STATE OF NORTH CAROLINA  
DEPARTMENT OF TRANSPORTATION

SUBJECT: **Revised Nationwide 33 Permit Application** for the replacement of Bridge No. 94 over East Prong Hunting Creek on SR 1972, Burke County. Federal Aid Project No. BRZ-1972(6), State Project No. 33413.1.1, TIP Project No. B-4047.

BRIDGE APPROACH SLAB
 DETAILS FOR PRESTRESSED
 CONCRETE BOX BEAM
 WITH BARRIER RAIL

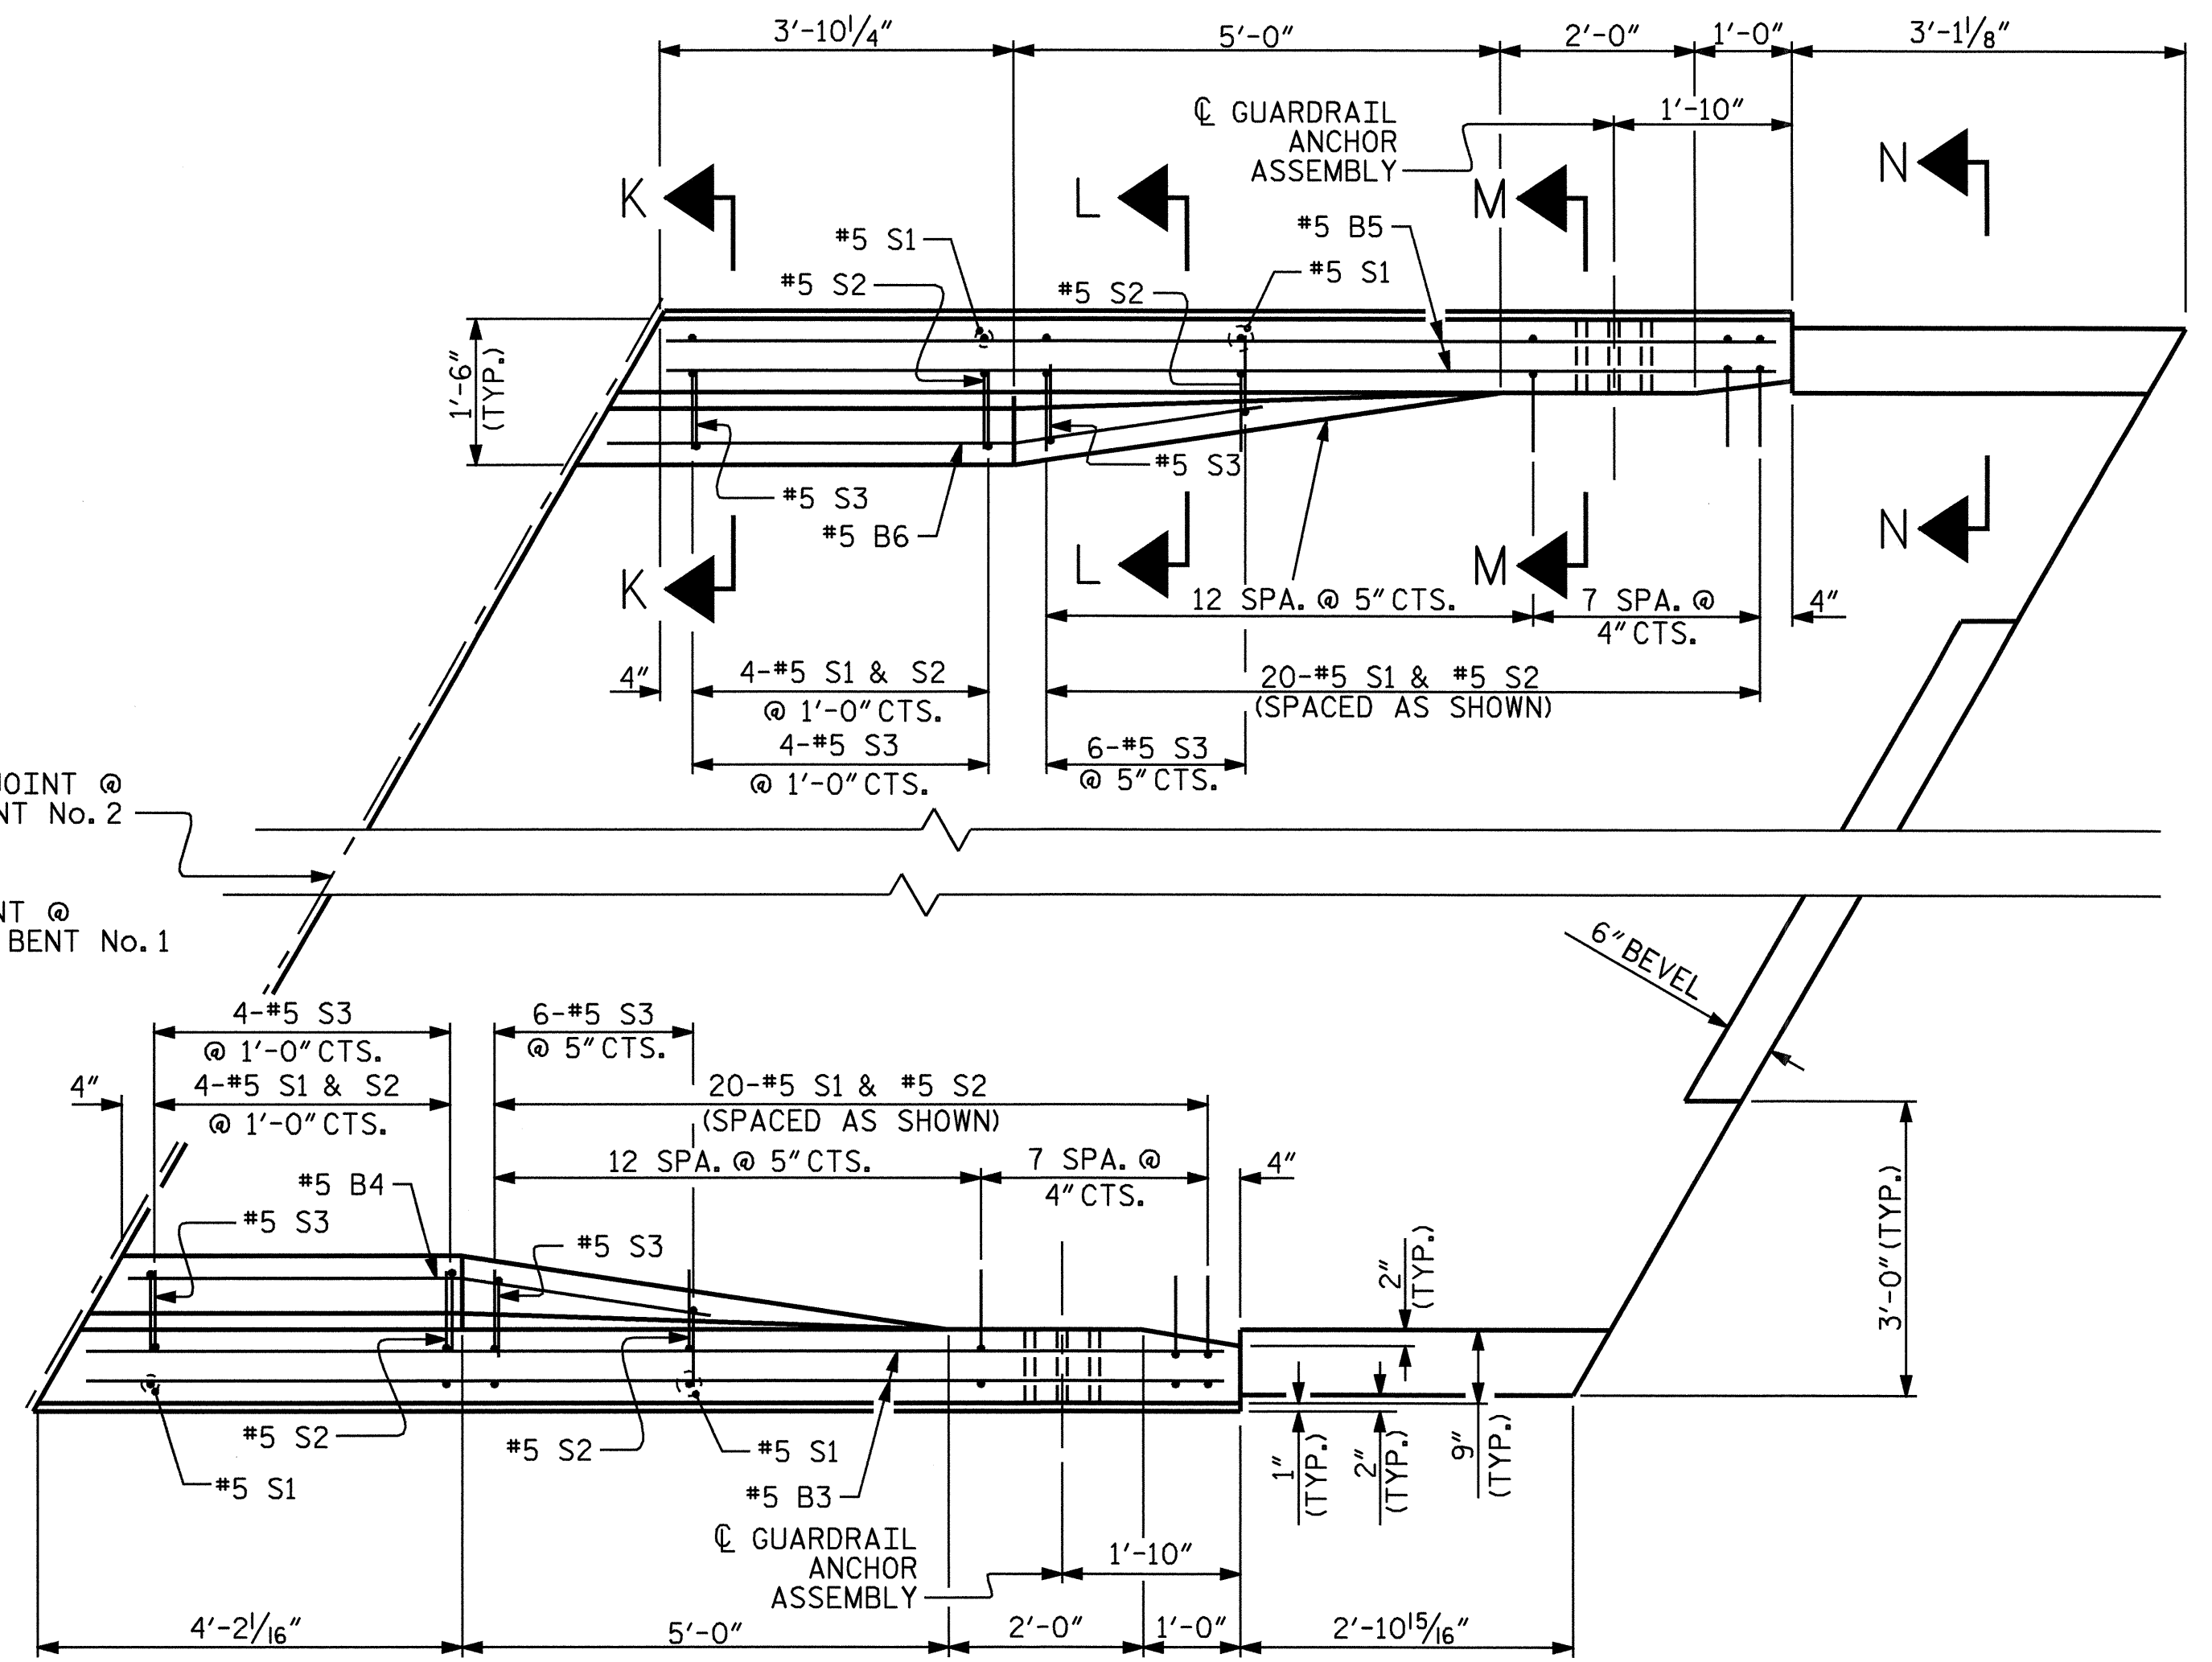
Please reference the original permit application for the subject project dated June 23, 2005. As you are aware, the NC Department of Transportation (NCDOT) proposes to replace Bridge No. 94 over East Prong Hunting Creek on SR 1972. Due to cost and low ADT, the approach slab has been reduced from 25 feet to 15 feet. The new bridge will be a two-lane structure approximately 140 feet in length and 33 feet in width. The original application incorrectly stated that the width was 28 feet. No other changes have been made; all proposed impacts to Waters of the United States remain the same. Please replace the appropriate drawings with the attached revised drawings.
